Fingallians GAA Club

**TII Submission for the Railway (Metrolink-Estuary to Charlemont via Dublin Airport) Order
2022**

**The following addendum document is the original written
submission from 2023**

Drawing Title: **METROLINK - GENERAL ARRANGEMENT BALHEARY DEMESNE (SHEET 3 OF 5)**

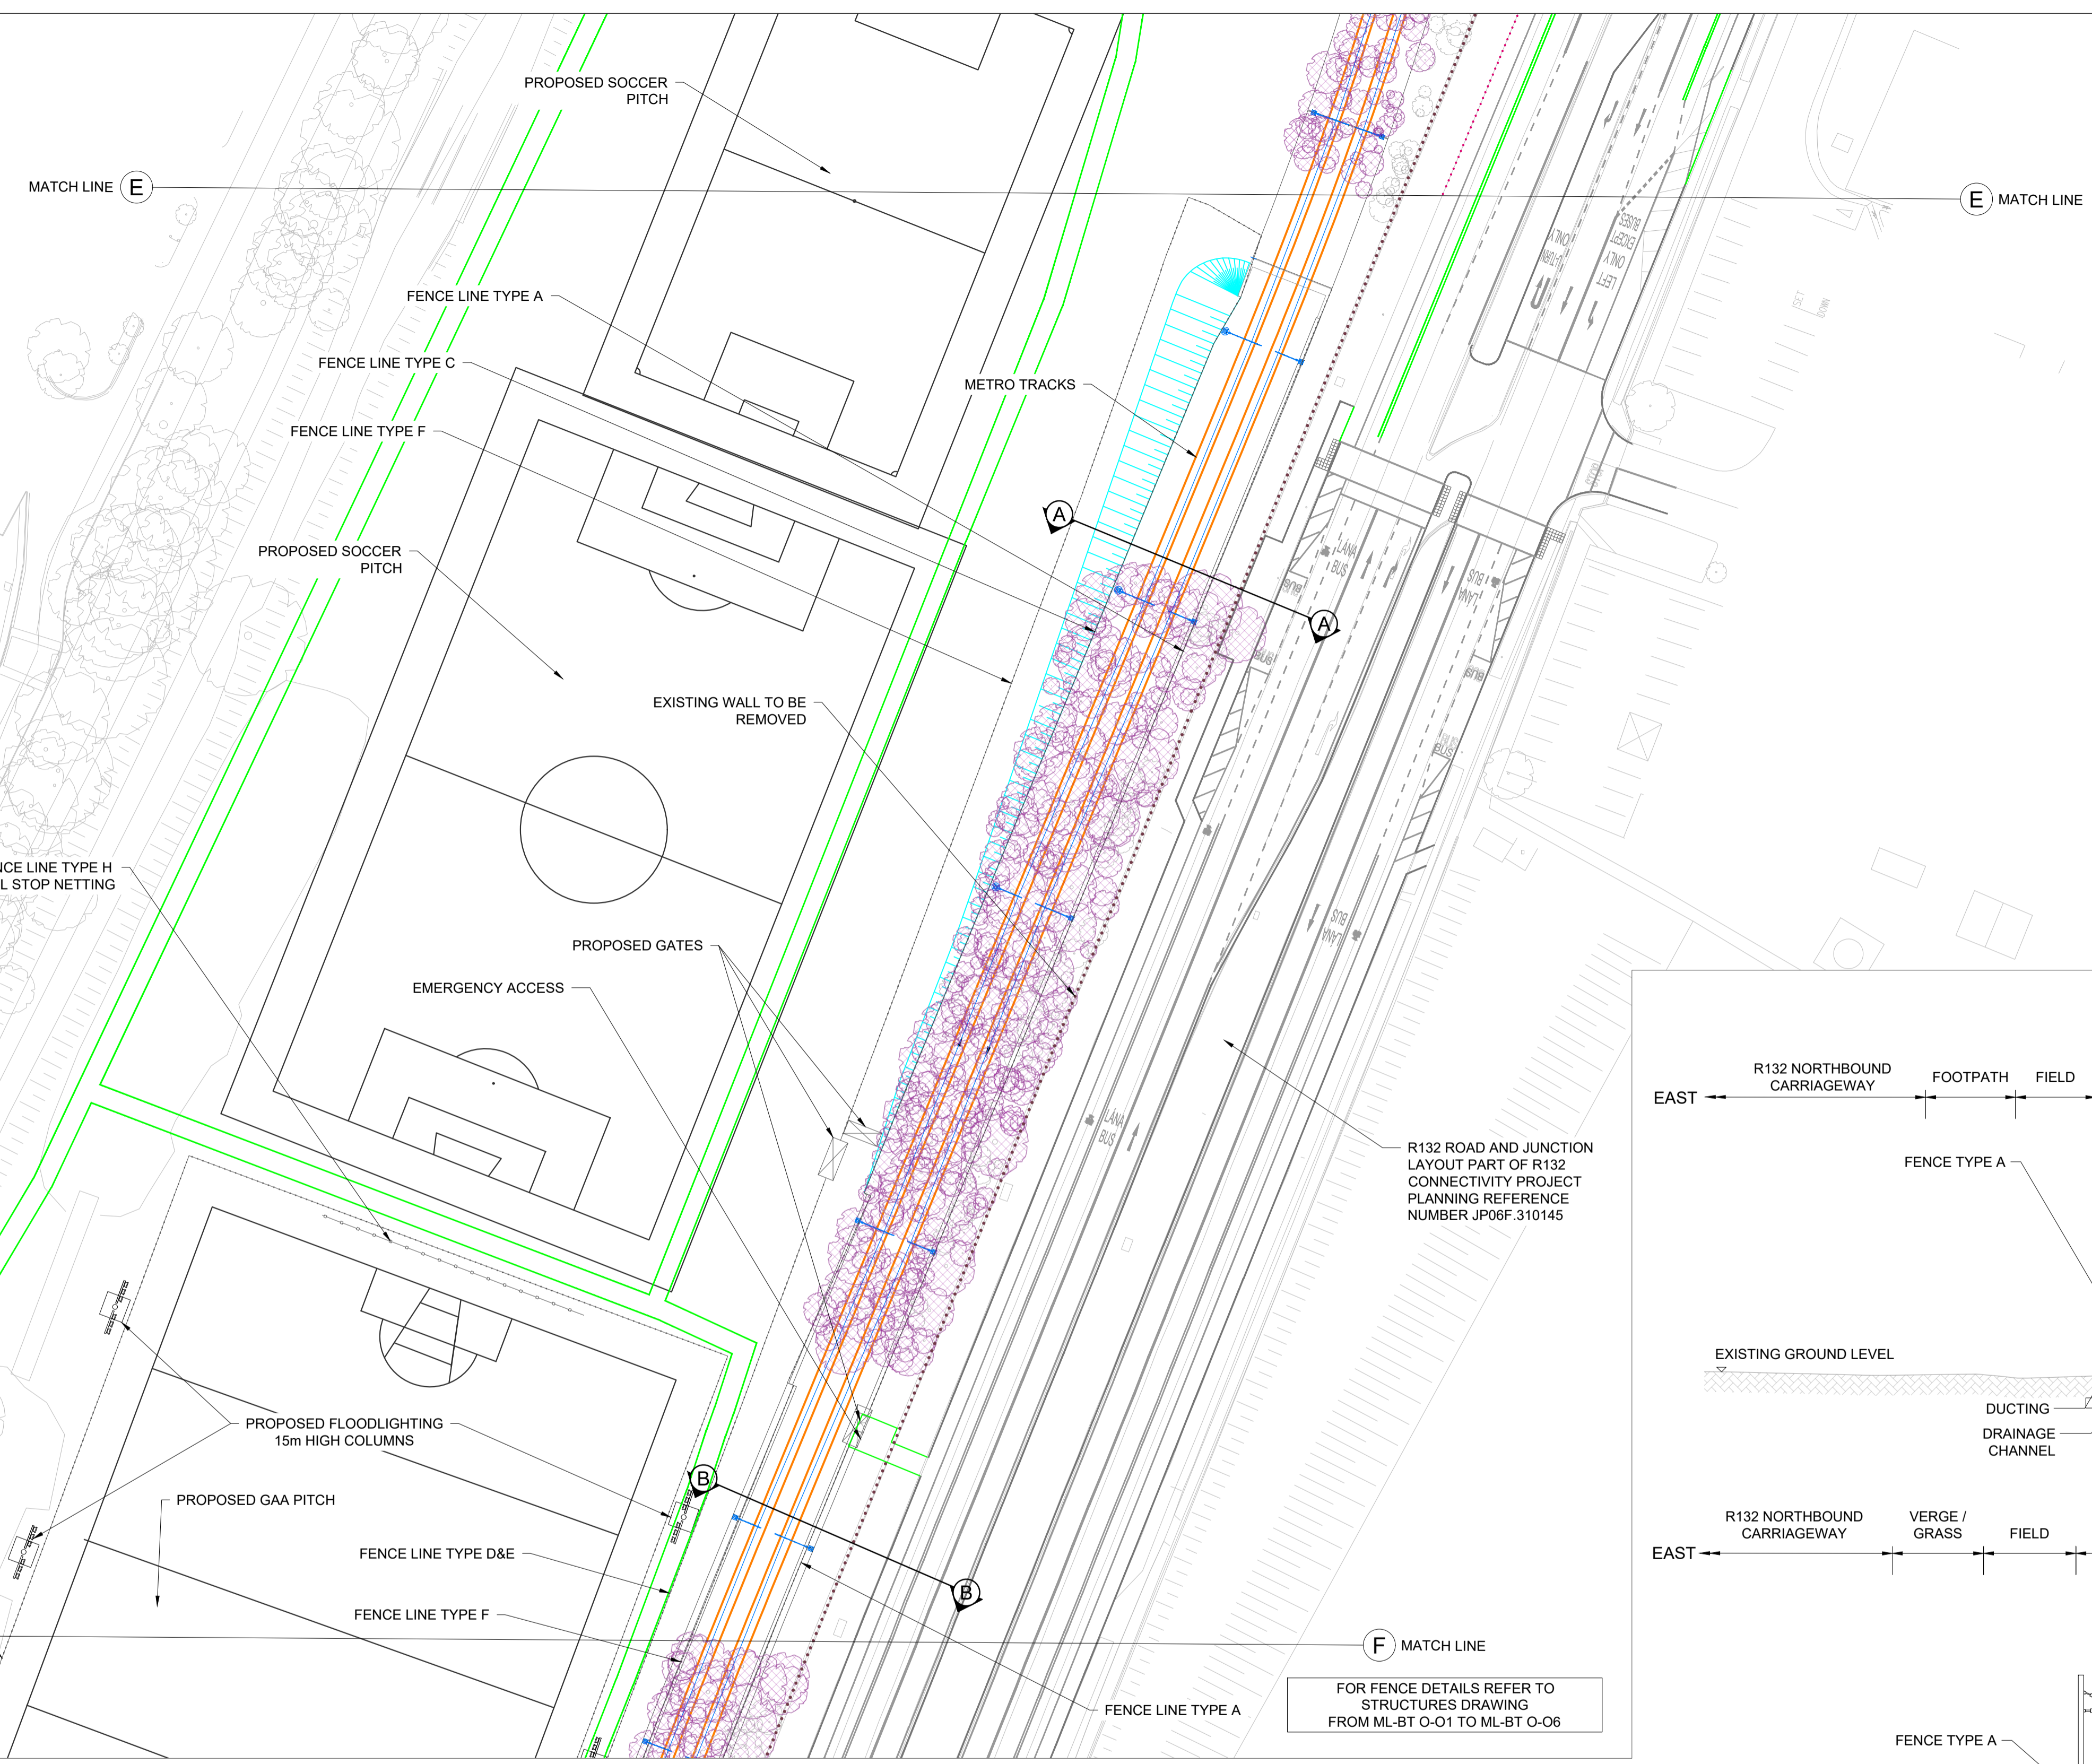
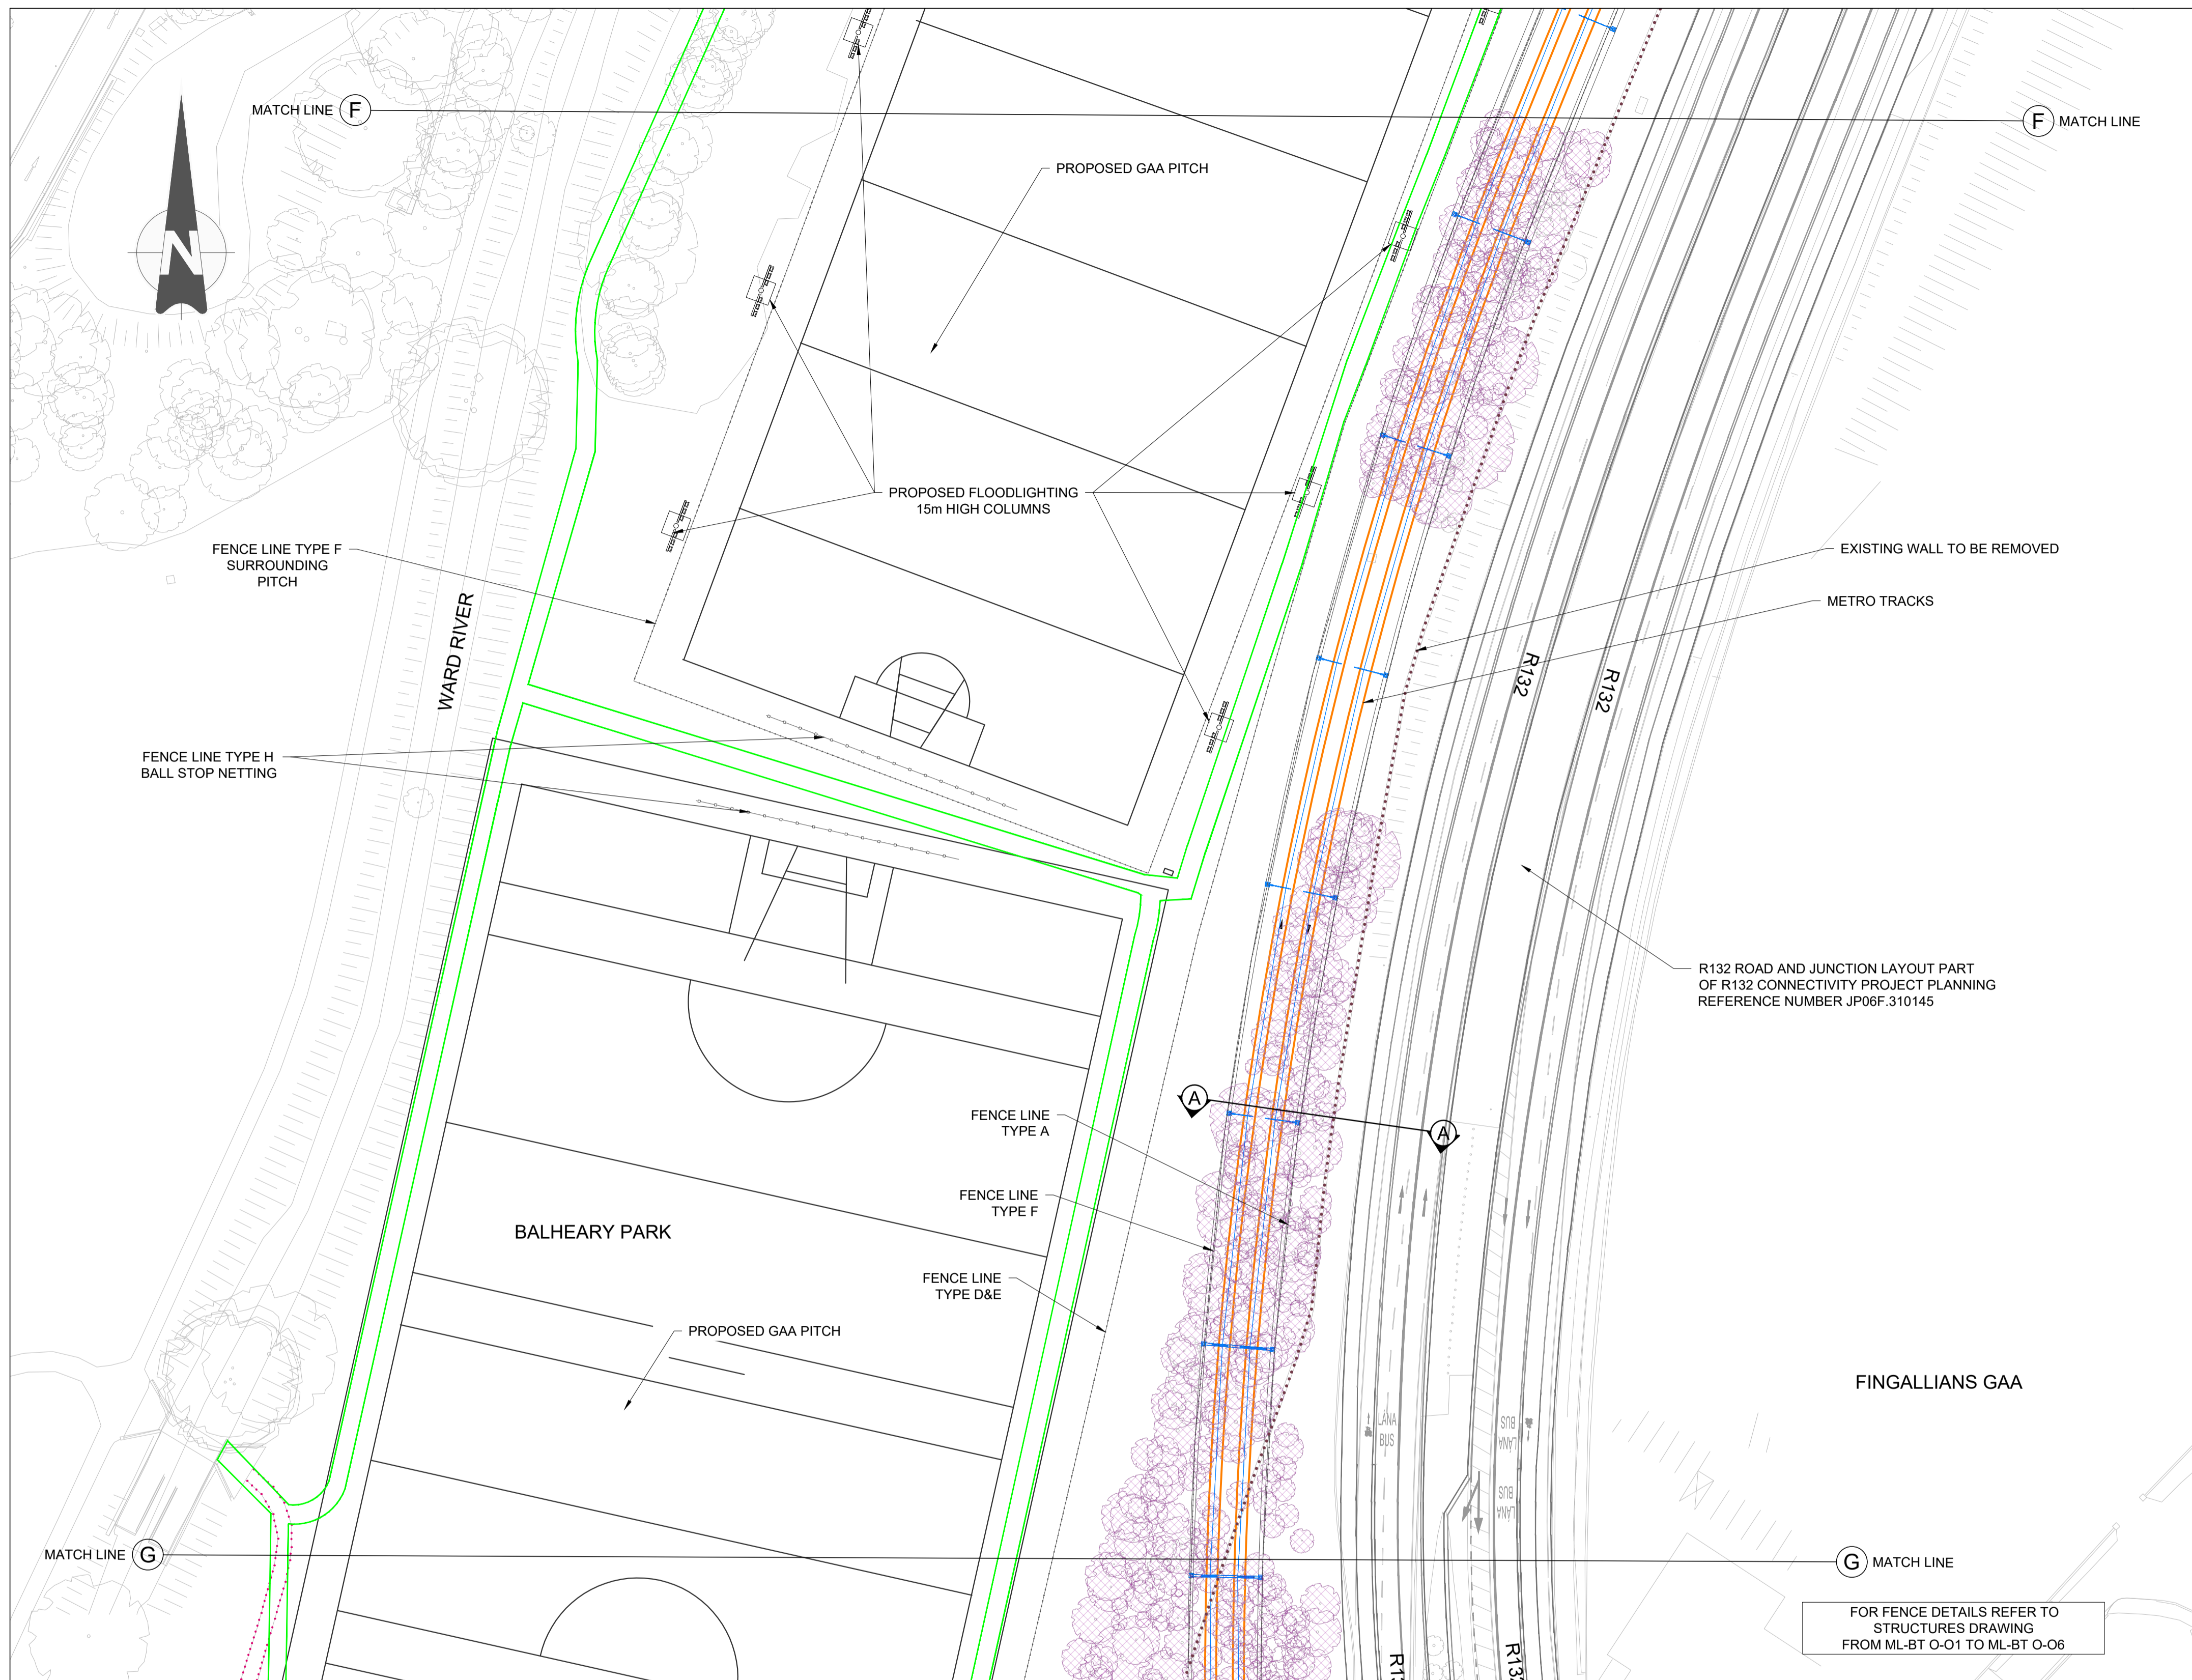
- Both full-size playing pitches will be unavailable for up to 12 months (estimate) as the southern-most pitch (pitch #1 below) has to be re-aligned. Pitch #2 will be developed as an all-weather but reduced in size when compared to the existing pitch. As a result, this pitch will not be suitable to host matches. While we welcome the intended provision of an all-weather pitch it is essential that the design is re-considered and increased to a full-size all-weather flood-lit pitch.

- The revised plan for the footbridge crossing the R132 suggests it will be permanently removed which is contrary to the original plan (see photo below). This will bring an increased risk to the large numbers of club members, particularly the exceptionally large numbers of juveniles, travelling teams, parents/supporters and the general public who access Balheary and LMP on a daily basis.

- Provision must be given to Fingal maintenance vehicles (grass cutting) and emergency access for an ambulance.
